Your Ref: 000013098
Our Ref: EP/54/12/
Please ask for:
Mr J Smith

Room in roof with hip to gable and front and rear dormers
28 Vermont Way East Preston

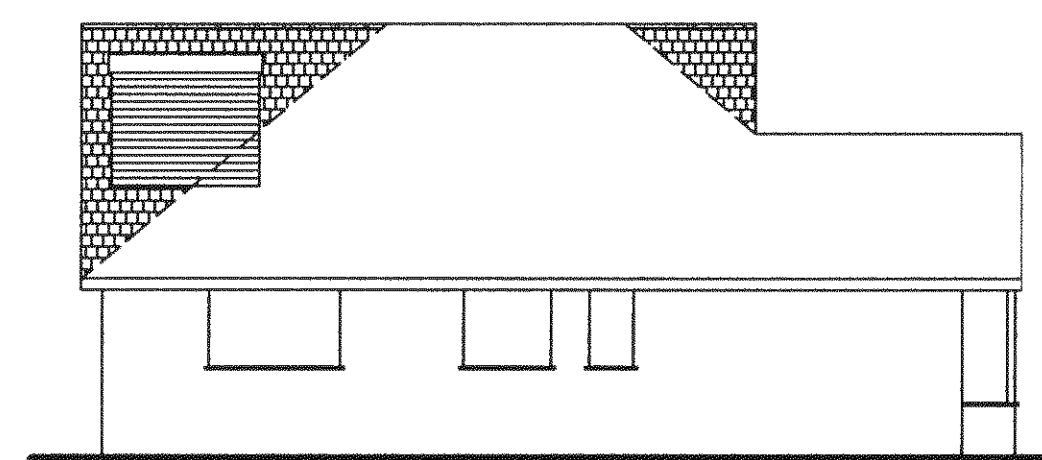
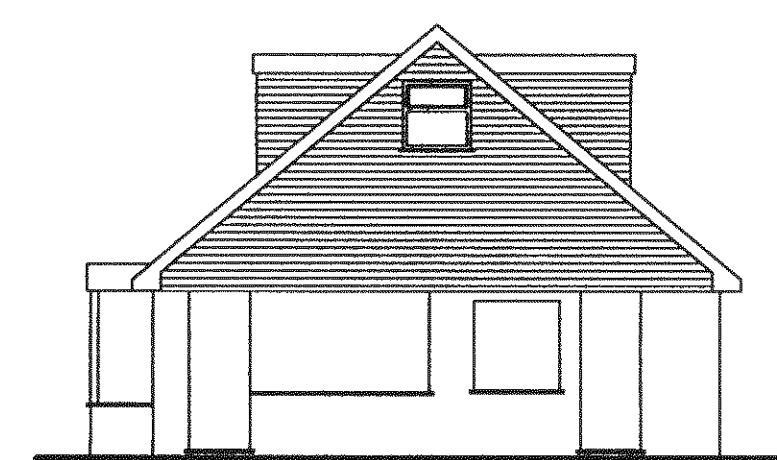
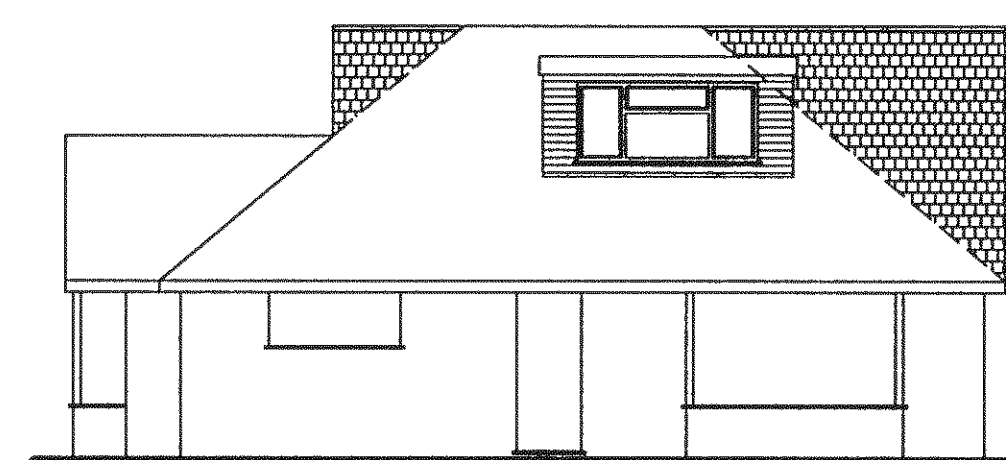
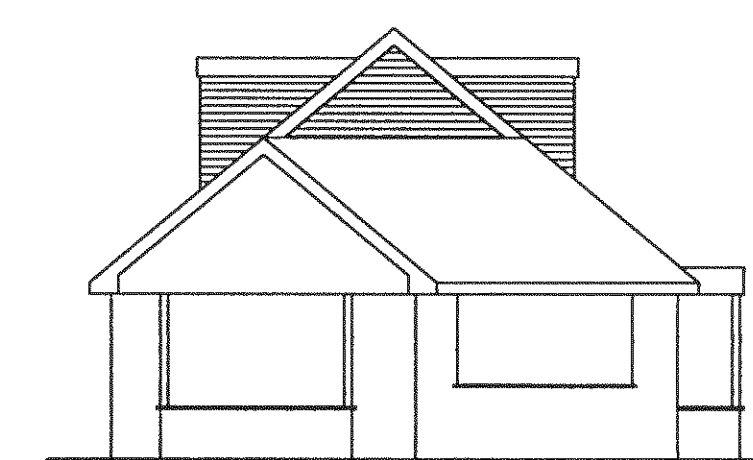
This application is an object lesson in how not to extend a bungalow. The proposed rooms in the roof produce dormers that are so large that they dominate the building, extending vertically to the ridge of the roof and horizontally to the outer wall. They produce a building of unbalanced, indeed nightmarish appearance. □

The proposal is therefore incompatible with policies DEV19 and GEN7 of the Local Plan, with the guidelines of the East Preston Village Design Statement, and the policies on design in paras.63 and 64 of the Planning Policy Framework. □
